CITY OF ALBUQUERQUE

**Re: NM Rail Runner Express, Montano Station
Engineer's Stamp dated 4-24-13 (F15/D032)**

Based upon the information provided in your submittal received 4-24-13, the above referenced plan can not be approved for building permit report can not be approved for building permit based on the following comments:

Sheet No. C-006

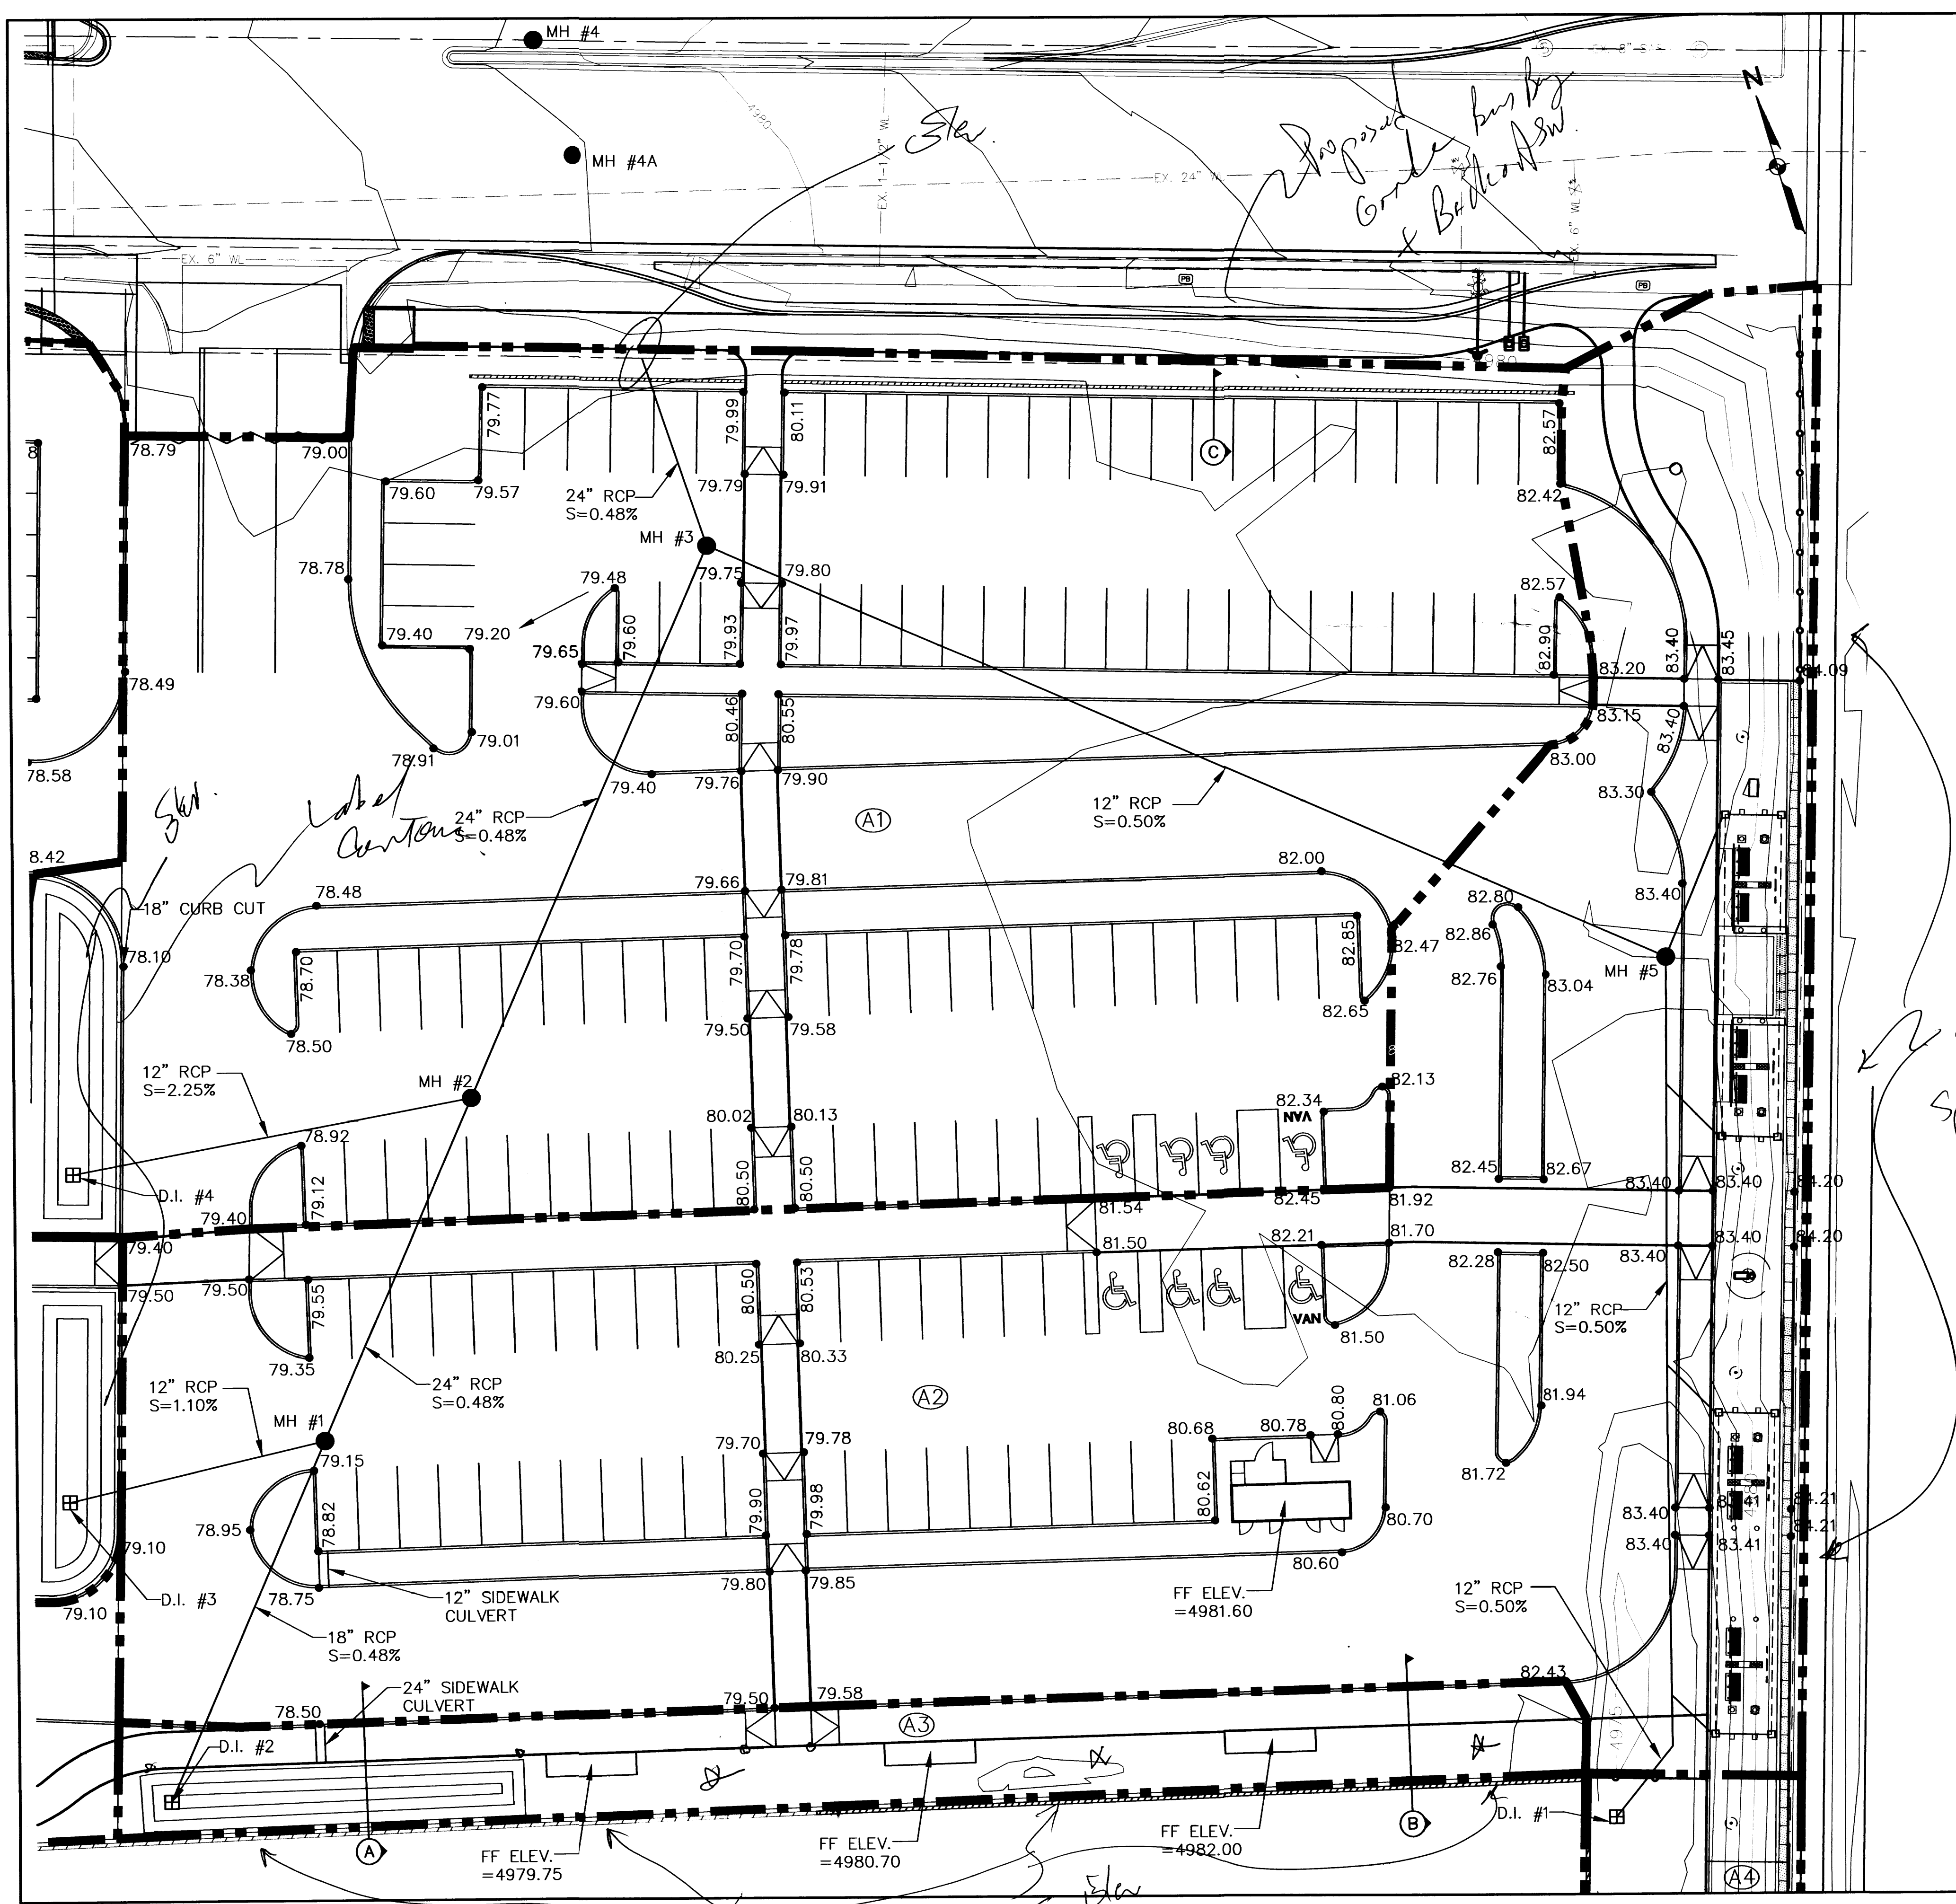
| PO Box 1293 | • Include a Vicinity Map on sheet C-006. |
| | • Show existing spot elevations and proposed sidewalk elevations along the southerly boundary on sheets C-006 and C-007. |

Sheet No. C-007

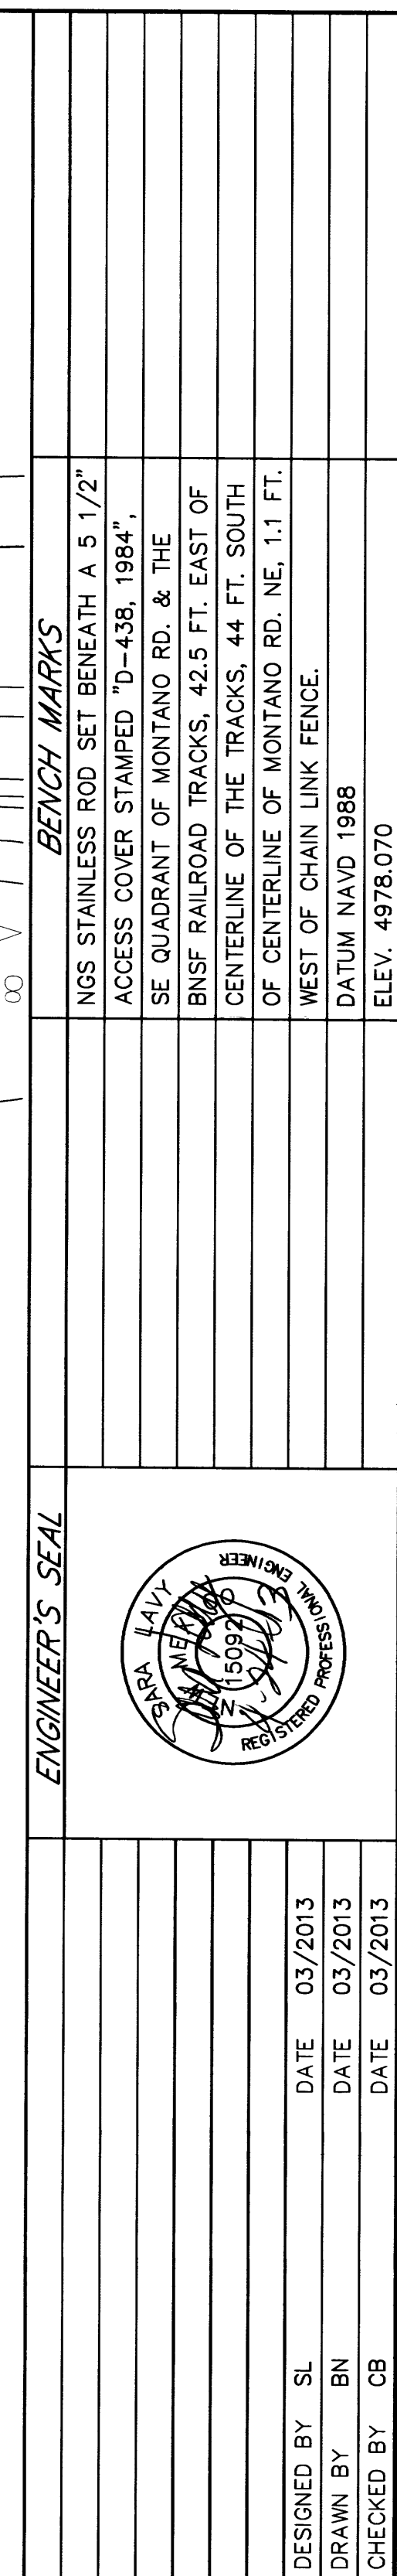
| www.cabq.gov | • Show existing elevations on the east side of platform on sheet C-007 and C-008. |
| | • Show existing spot elevation along the security wall on sheet C-008. Label existing contours. How does the proposed contours into the grades at the north east side of the proposed security wall. Show proposed grades on all the sheets. Sheet C-007 does not show proposed elevations from Sheet C-008 nor sheet C-008 show proposed grades from sheet C-007. |

Sheet No. C-008

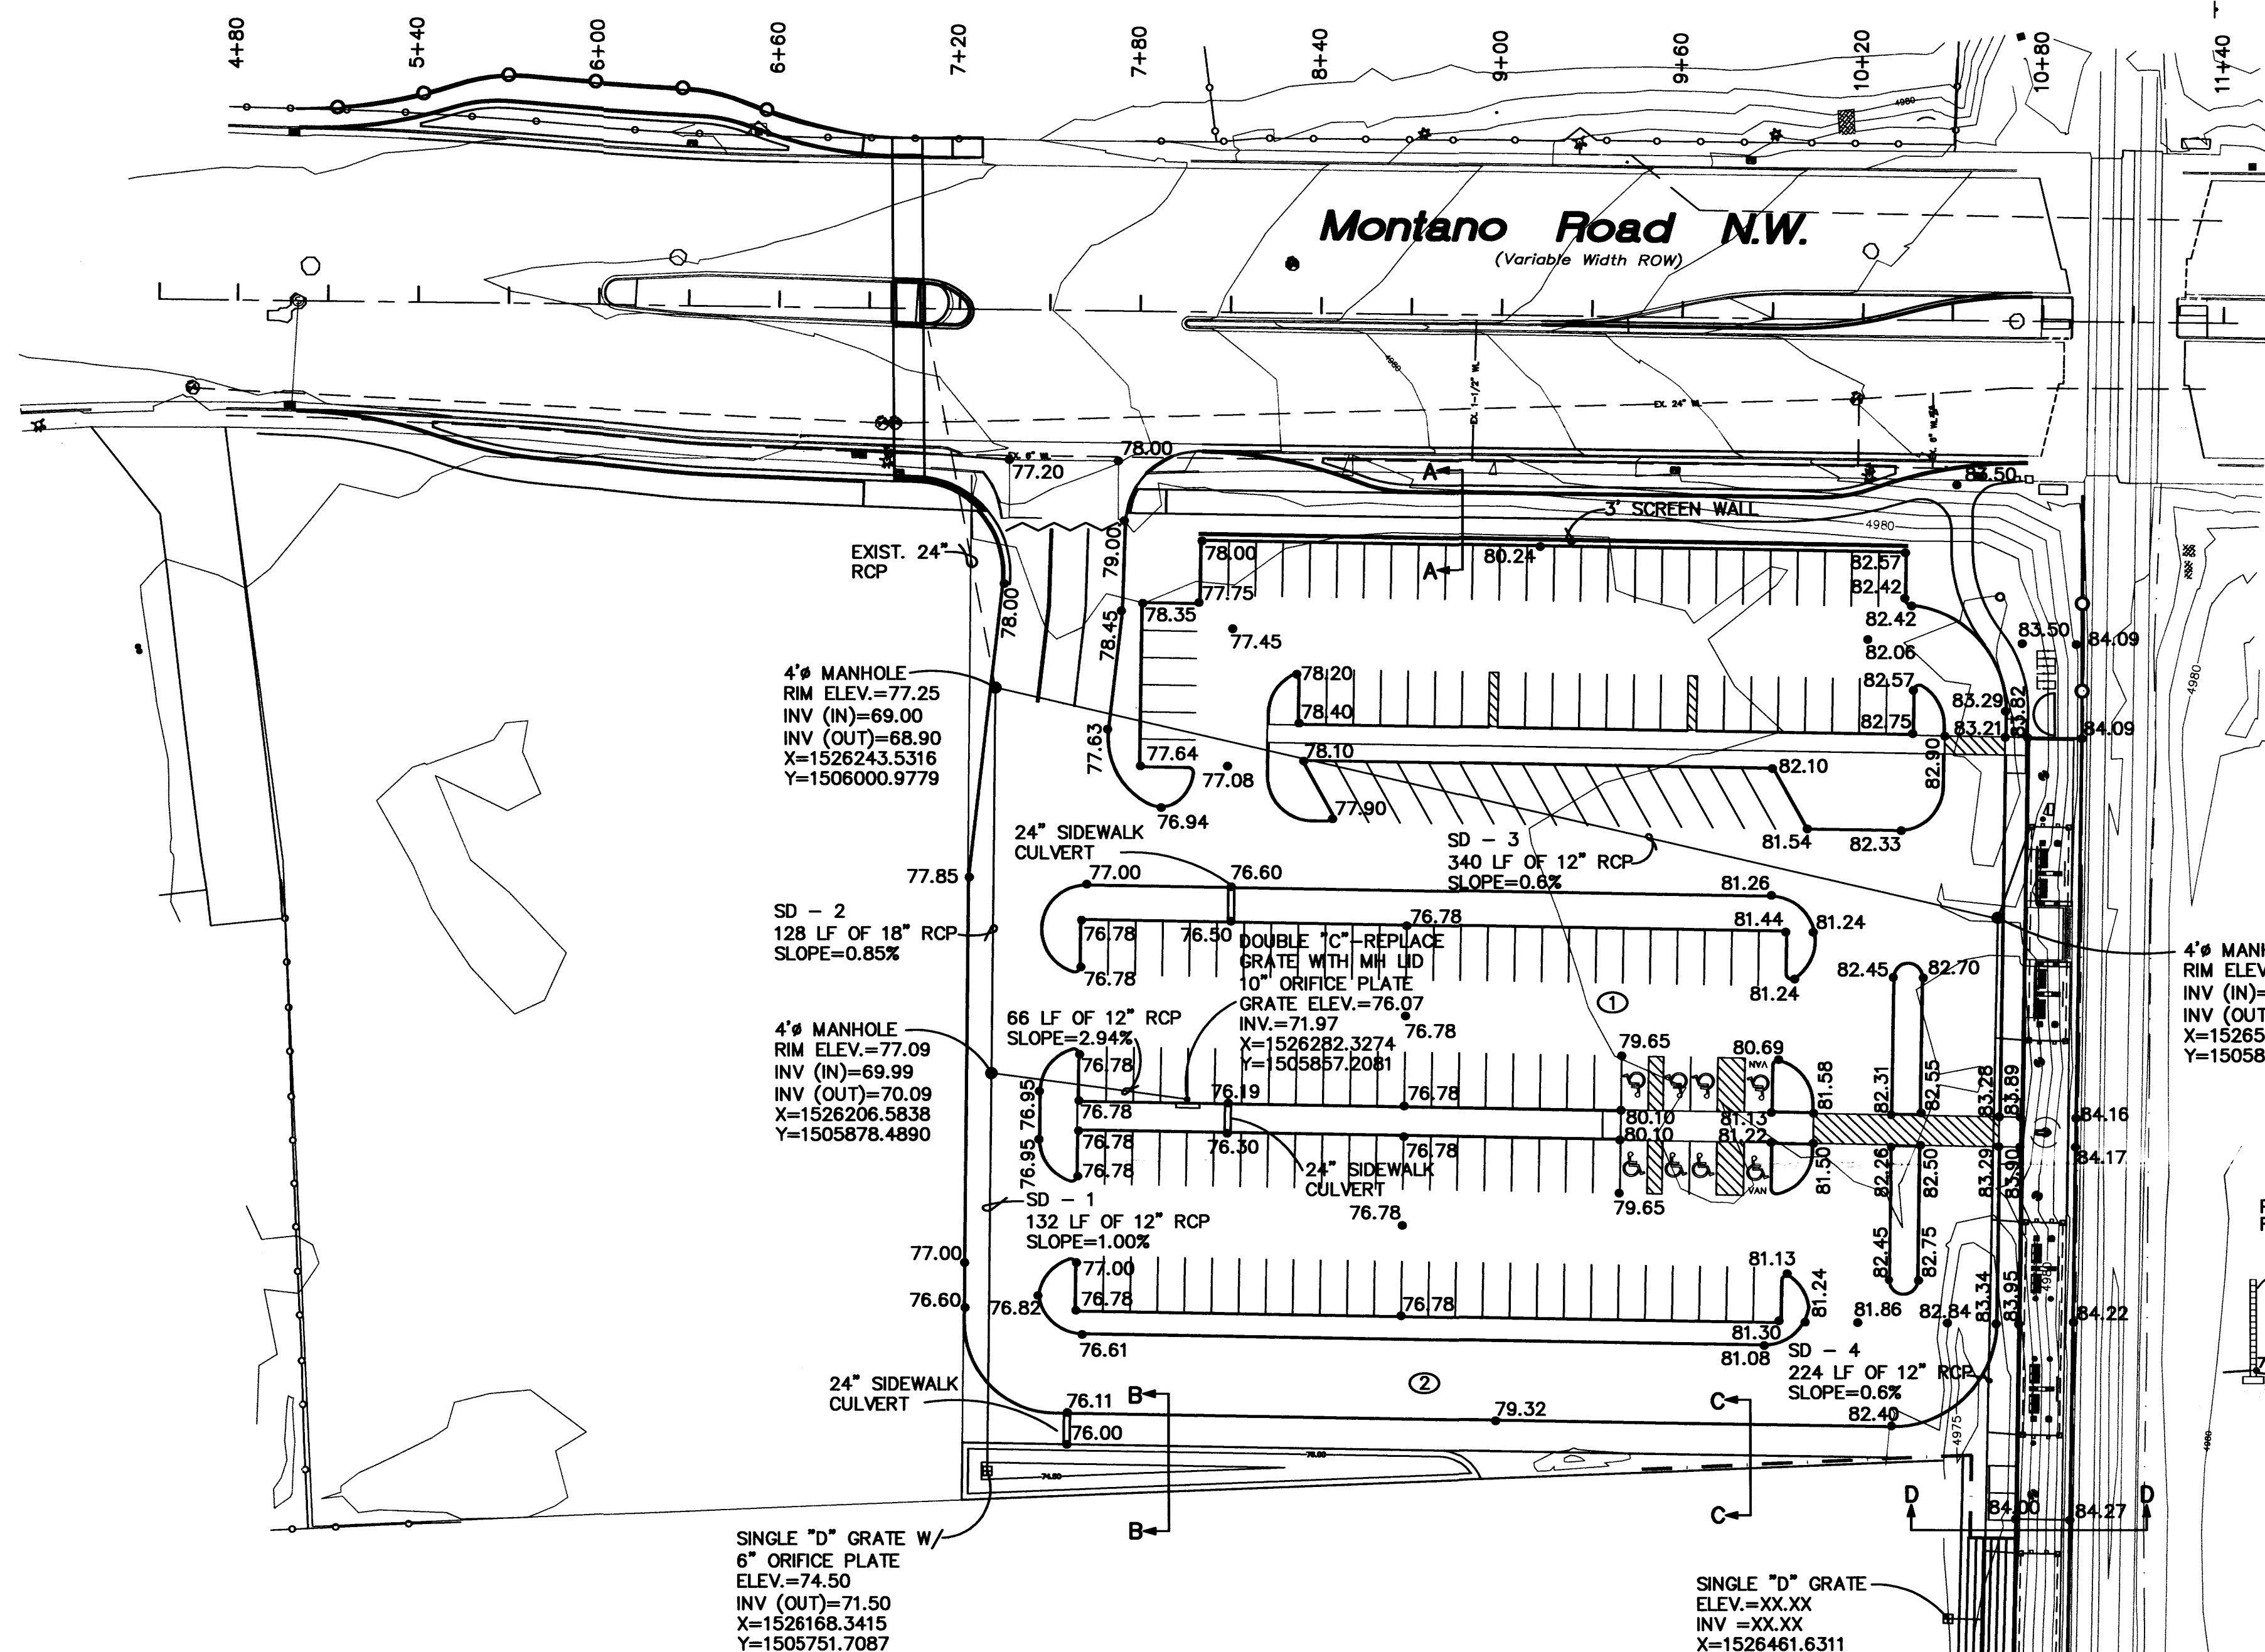
| | • Show proposed elevations on all the sections shown on sheet C-008. Slopes greater than 3:1 will require slope treatments. Scale shown on Sheet C-008 is not standard. Maintain the same scale between plans. |
